Our Case Number: ACP-323873-25

Re: Kingston Park and Millers Lane - Public Park Urban Realm Project
Kingston Park & Millers Lane, County Galway

Re: Proposed Sports & Community Development, Millers Lane, Galway City

Executive Summary – Key Issue: Pavilion Siting and Height

JOB TITLE	KINGSTON PARK & MILLERS LANE - PUBLIC PARK & PUBLIC URBAN REALM PROJECT		
DRG. TITLE	PROPOSED GROUND & FIRST FLOOR PLANS PLANNING STAGE

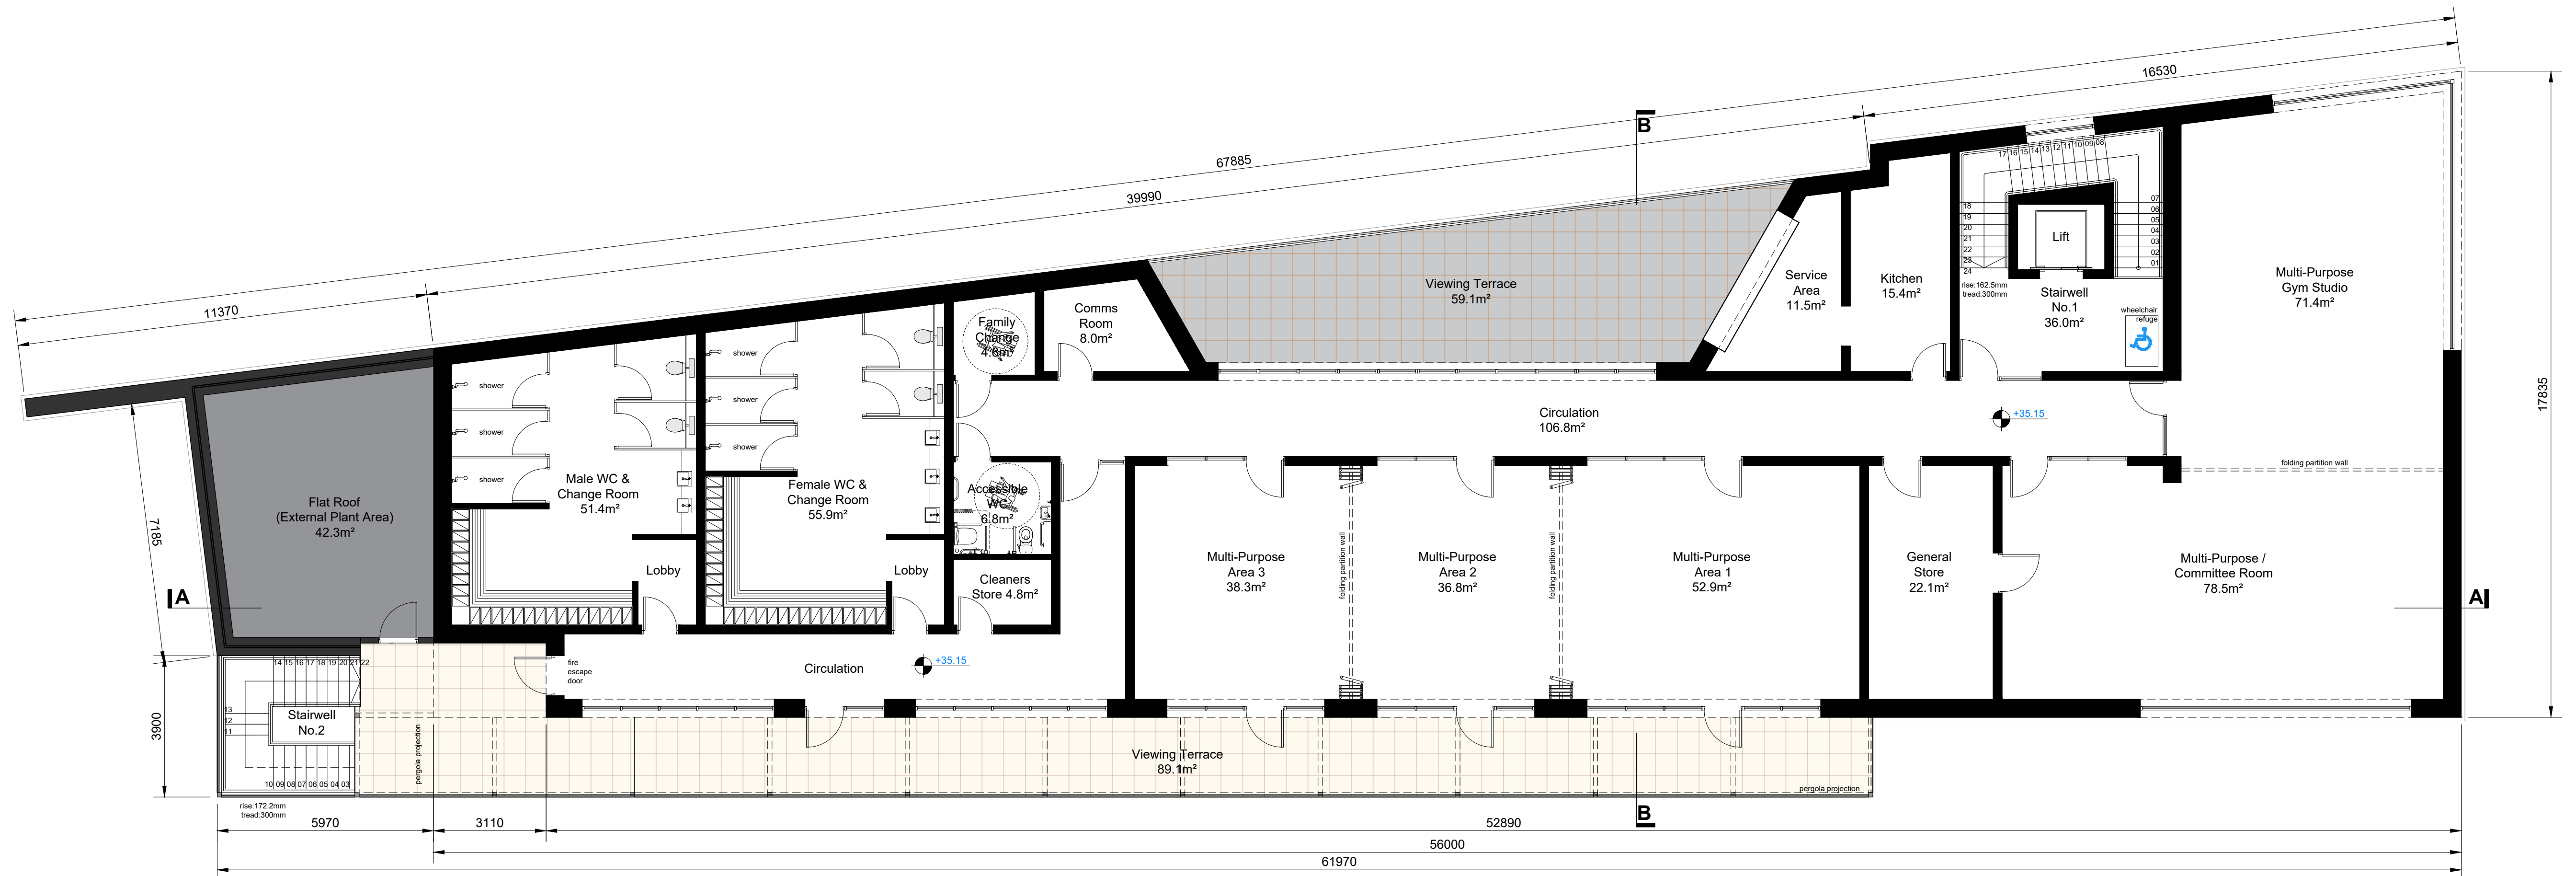
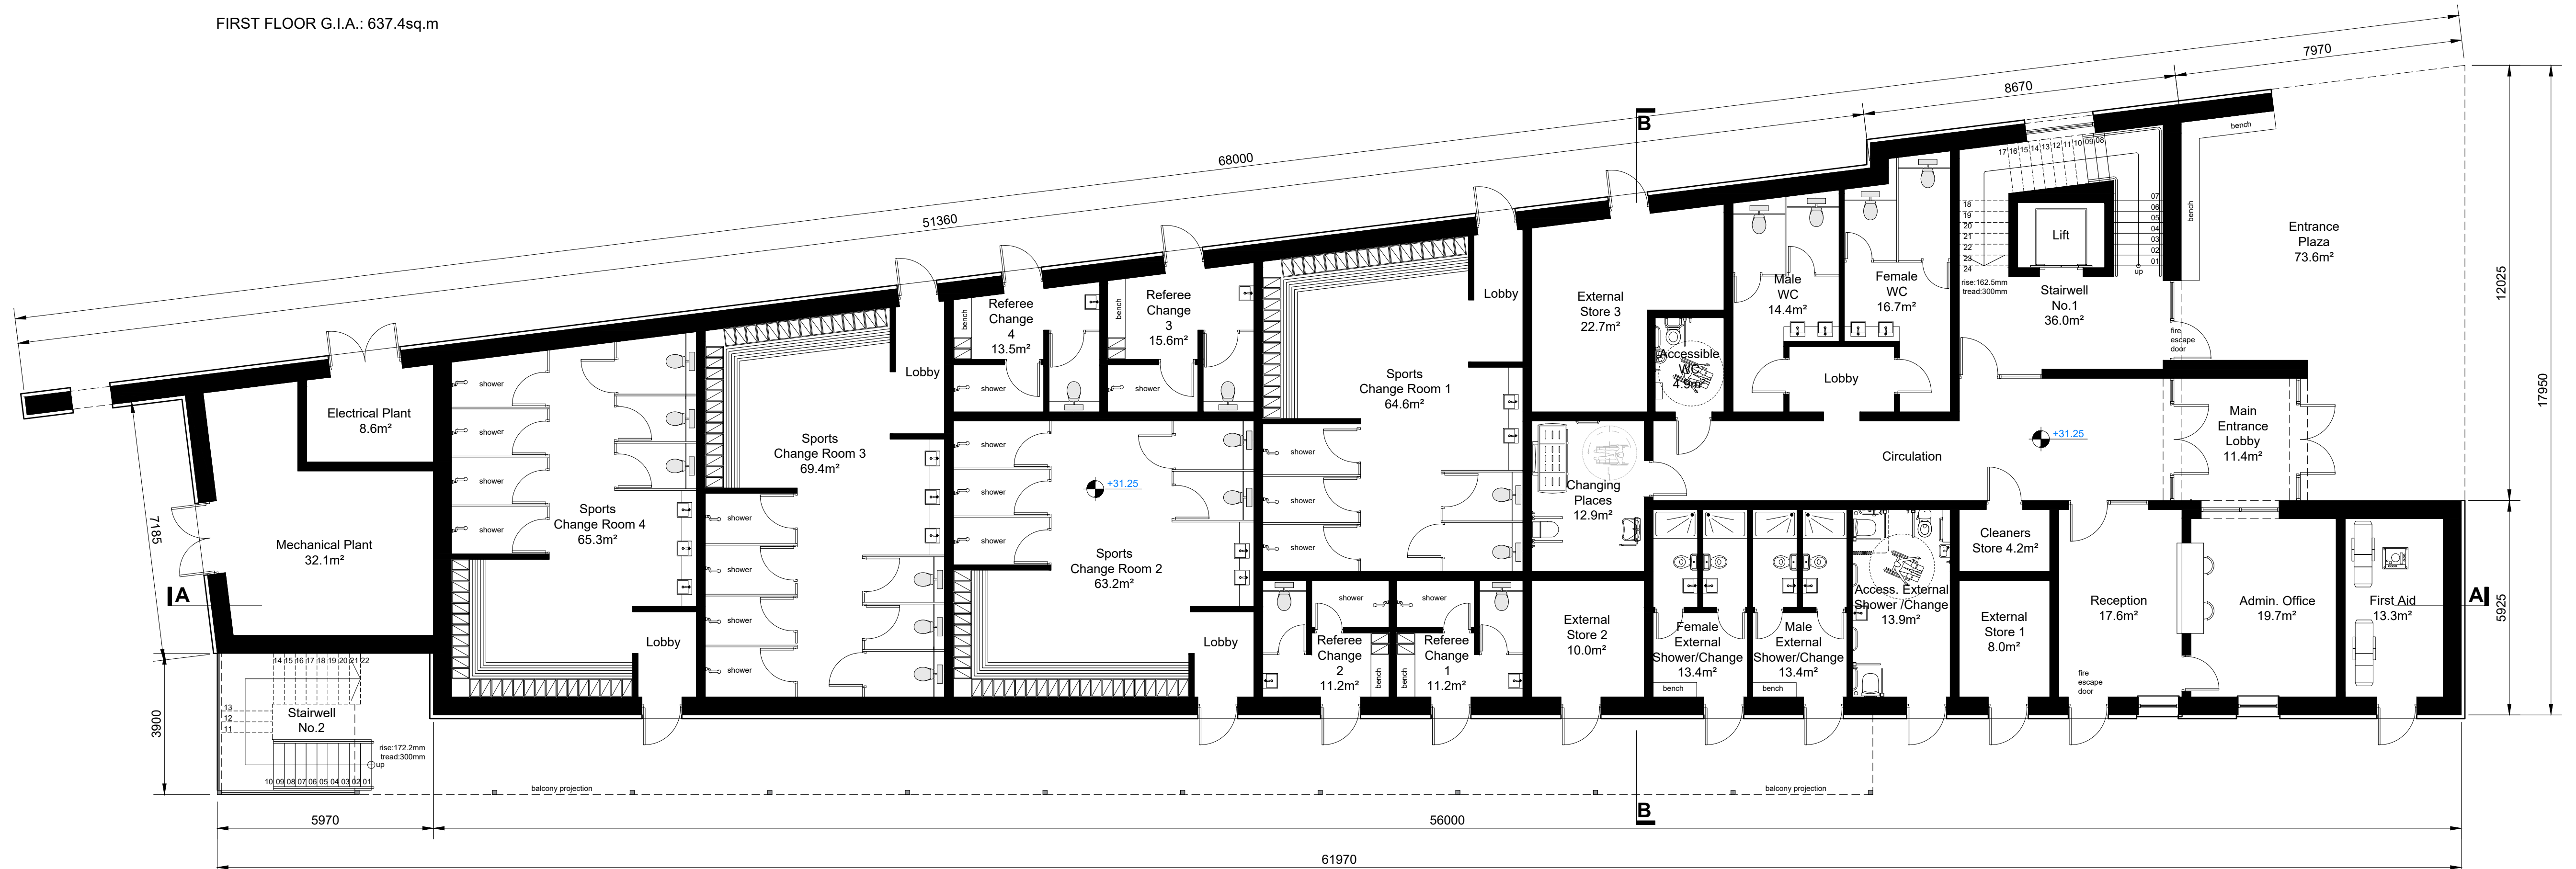
the inappropriate siting, height, scale and cumulative amenity impact of the proposed two-storey pavilion building and its associated ancillary structures (equipment store, bike shelter, smoking shelter and bin store), located immediately behind existing dwellings, including my own.

The proposed two-storey pavilion represents the **principal planning failure** of the scheme.

Despite the site being enclosed on three sides by established residential estates, the pavilion has been positioned centrally within the park and tight to rear residential boundaries, rather than along the road frontage where it could be appropriately accommodated within the urban structure.

At a separation distance of approximately 40 metres, the **height alone** is unacceptable. A two-storey building incorporating viewing terraces, internal activity spaces and congregation areas fails to respect the established residential context, particularly where all affected rear gardens directly face the development.

Immediately behind the pavilion and directly along my boundary are:

- equipment store
- secure bike shelter
- smoking shelter
- refuse/bin store

The flat or shallow-pitched roofs of these structures create an effective stepped access route, enabling potential access to rear gardens, boundary walls and potentially dwelling roofs. This is a **material planning concern** arising from layout and design.

The proposed smoking shelter directly behind private gardens will inevitably result in:

The location of a refuse store directly against a boundary wall backing onto a dwelling introduces avoidable noise, odour and visual clutter, contrary to good practice and residential amenity standards.

- relocation of the pavilion to the road frontage
- reduction in building height
- removal of all ancillary and servicing structures from residential boundaries
- omission of the smoking shelter and bin store at residential interfaces

Drawing file: Landscape / P612-MIL-LD-BD-402.pdf

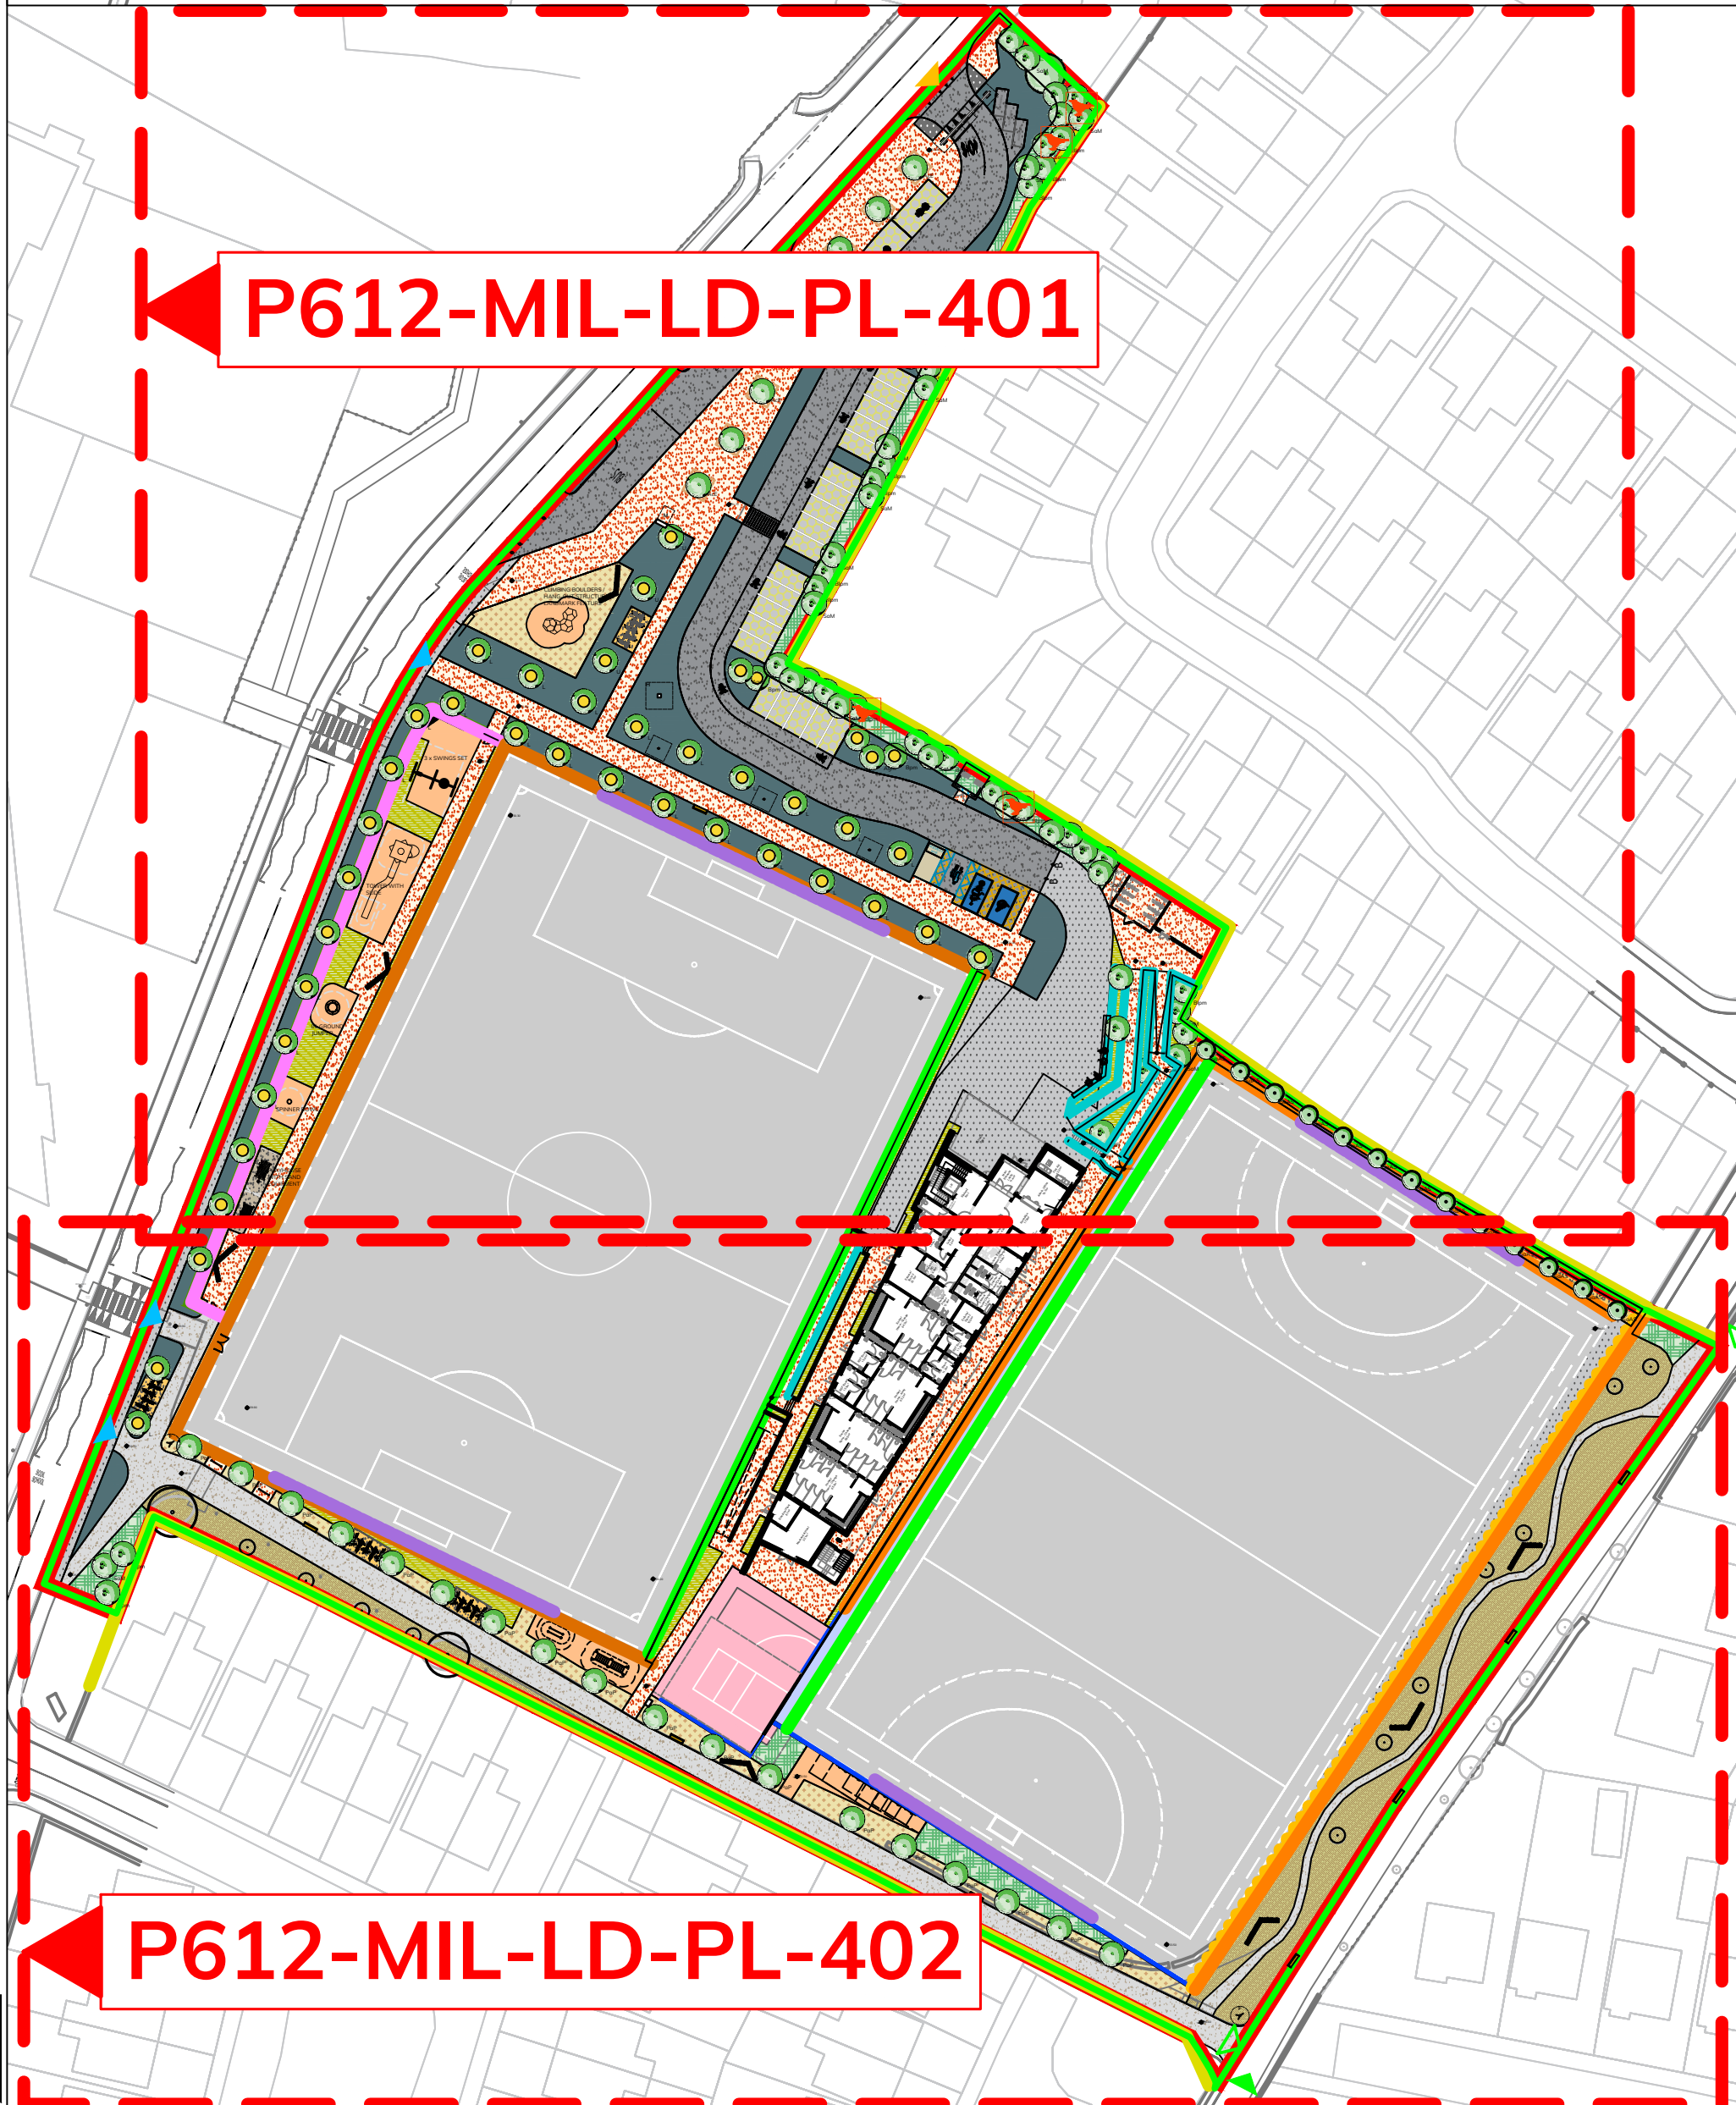
A 4.5m high BEGA lighting column is proposed close to the Gort Gréine boundary. Notwithstanding its “dark sky” specification, its height and proximity are likely to cause light spill and glare into rear gardens, contrary to **Policy 11.3 – Residential Amenity (Lighting)**.

Boundary planting proposals lack height limits or management commitments. Uncontrolled growth risks long-term loss of daylight, particularly when combined with the proposed building massing.
